Submission to The Department of Planning Industry and Environment New South Wales

Re: Pymble Ladies College Grey House Precinct, SSD-17424905

Ms. Judith A Bishop and Dr. Ian P King

EAST / WEST ELEVATION

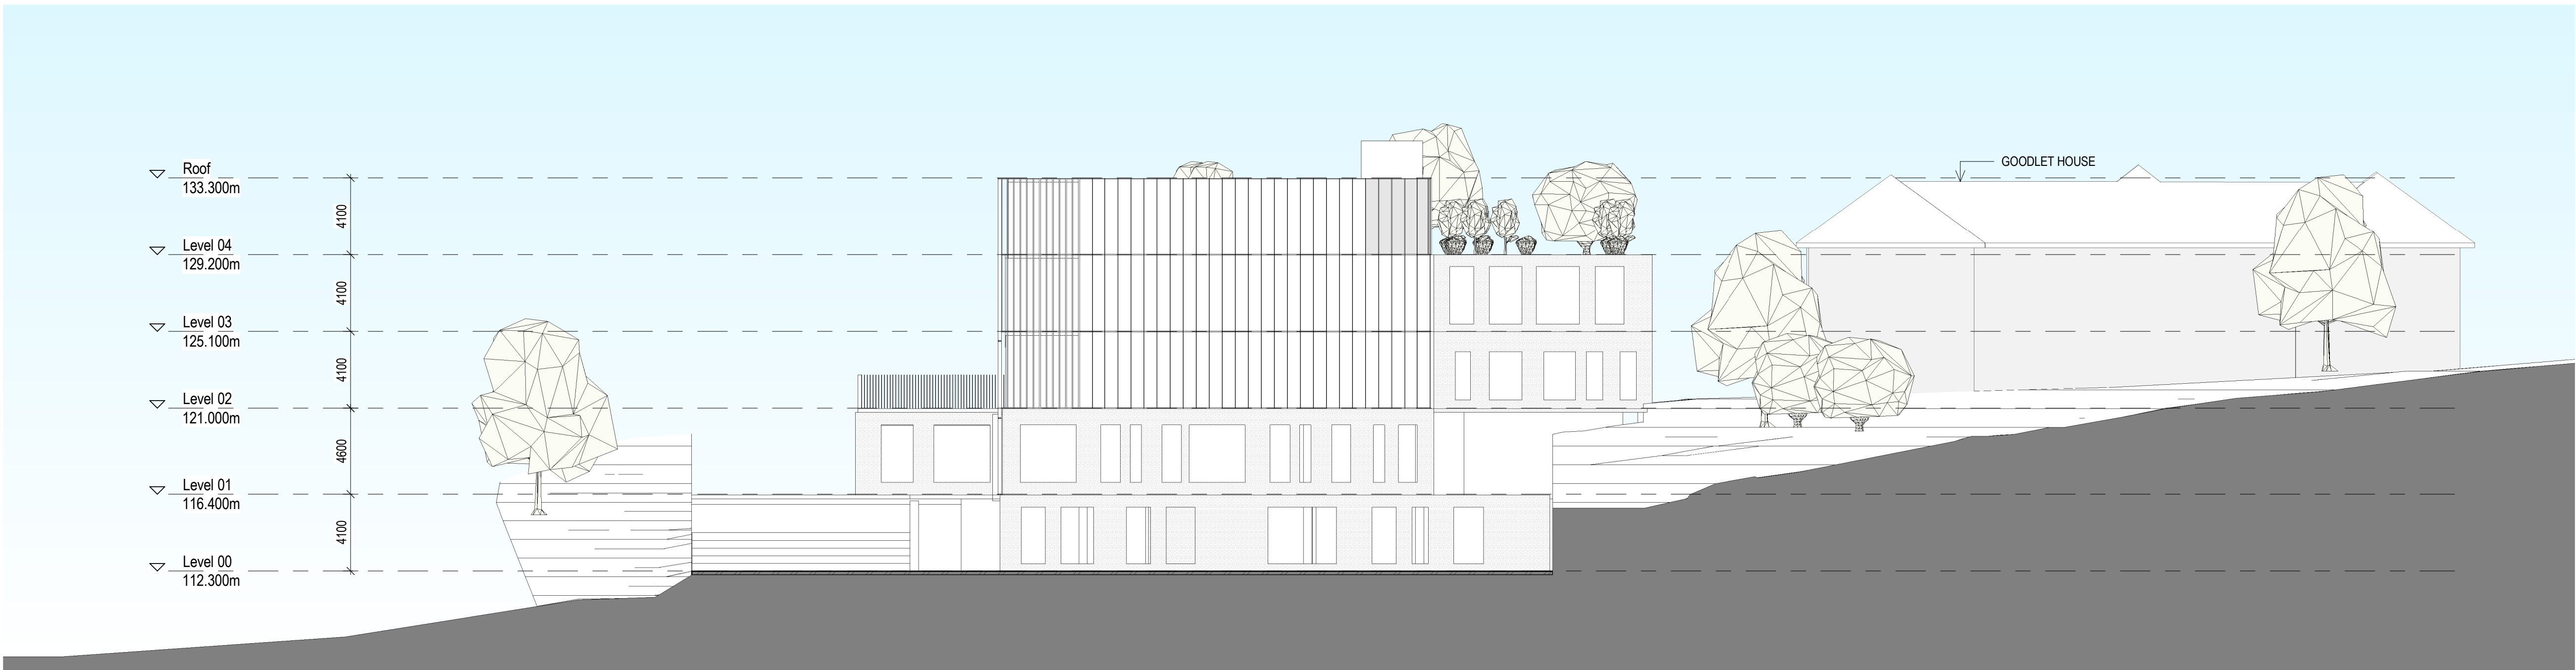
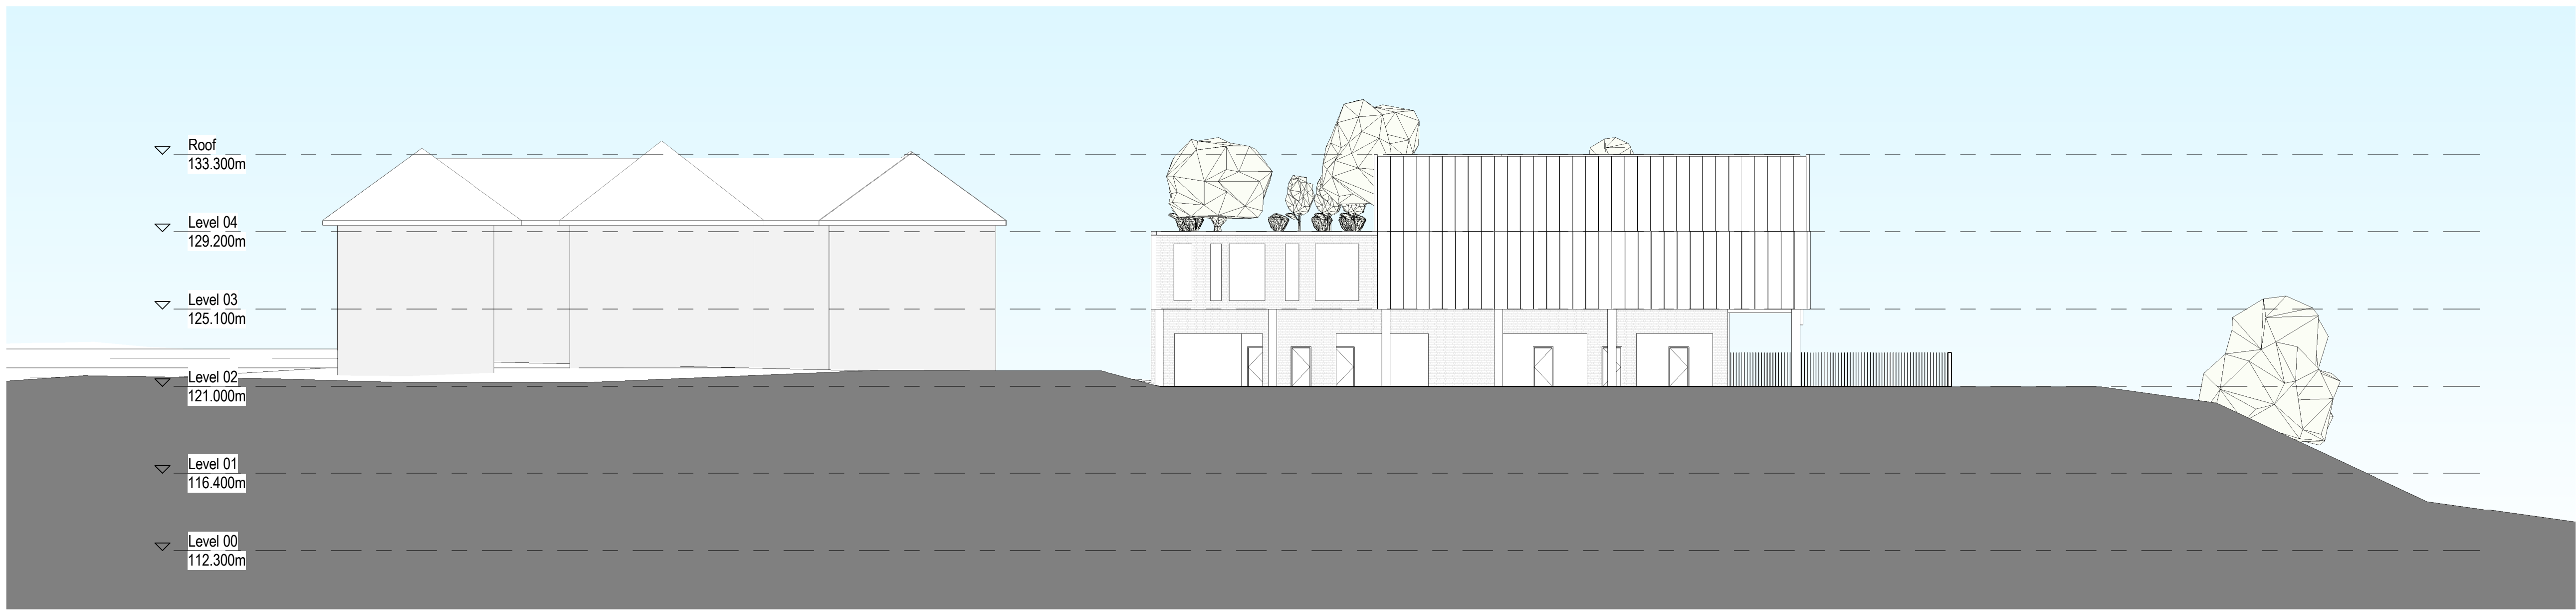
- 1 The five-storey bulk of the proposed structure is out of keeping with the heritage streetscape of the area. Despite references to it being three storeys on the uphill side, it will be a five-storey building when looked at from the east/south-east and will be very visible from Pymble Avenue. Architecturally, it will be out of keeping with the chapel which currently forms the skyline. My suggestion would be reduction of the height to 4 storeys for the easternmost half so that it steps up the hill and will then be less blocky. It would then probably have a benefit of more sunlight for the neighbouring properties. These issues are raised in Table 31 of the Government Architect Response to the proposed structure and are not satisfactorily addressed by the proposers.

(1) a small reduction in size of the new building to 4 storeys would reduce the visual impact of this inappropriately large building.
